Our Ref: LU/260/18/HH
Your Ref:

Town & Country Planning Act 1990 (as amended)
Town & country Planning (Development Management Procedure) (England) Order 2015
Application for Planning Permission for Works or Extension to a Dwelling

Development Two storey side extension, demolition of existing garage and outbuilding, construction of new annexe.
Location 22 Roman Acre Littlehampton

Elevation (north - east)

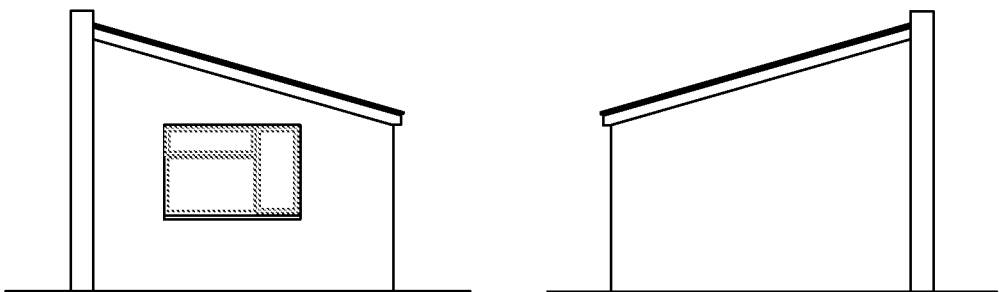
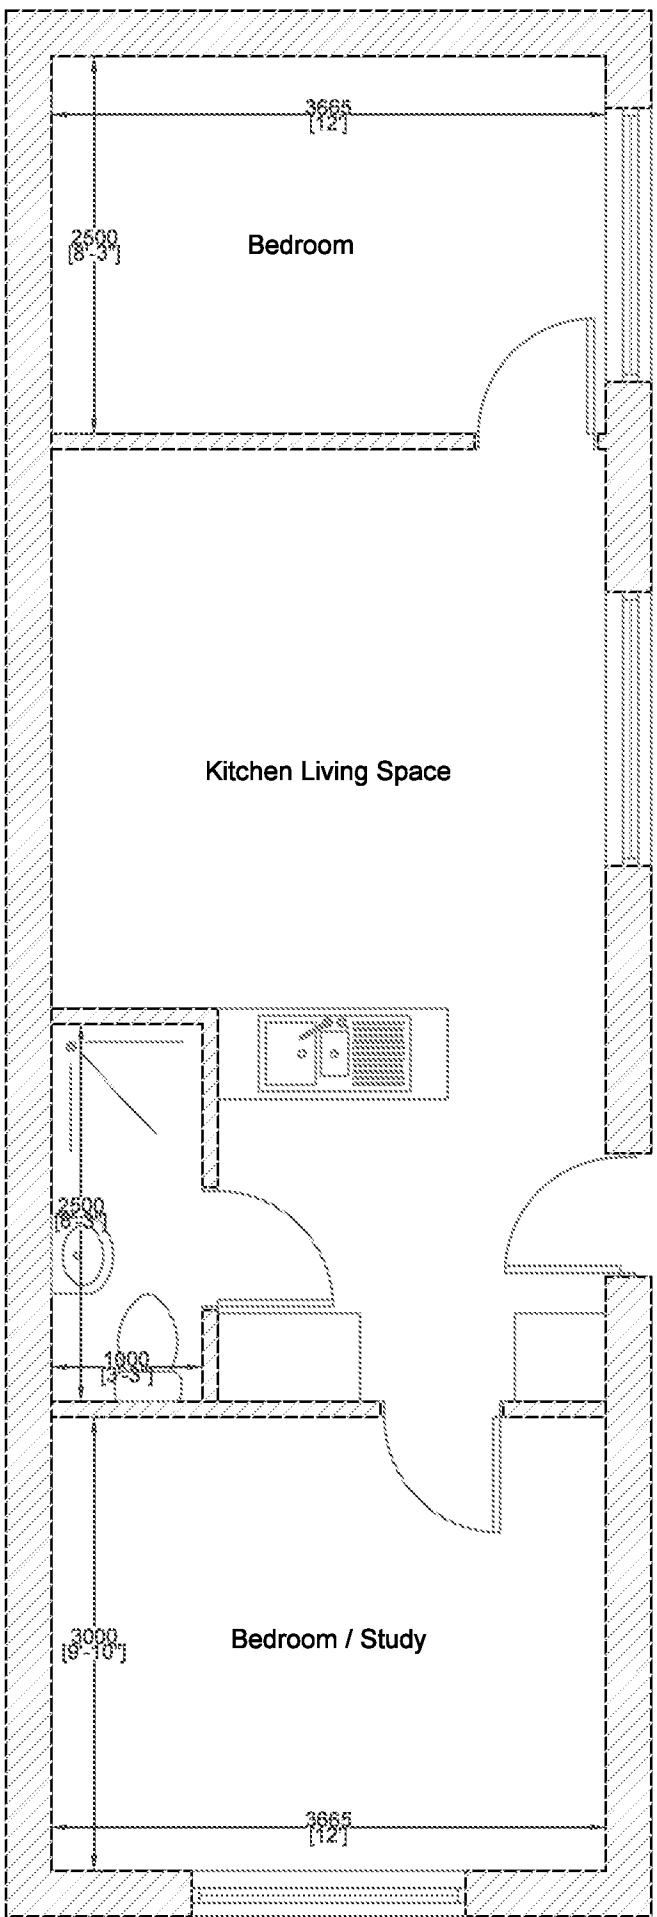
Plans Inconsistent

The window does not match between the proposed outbuilding north east elevation and proposed floor plan.
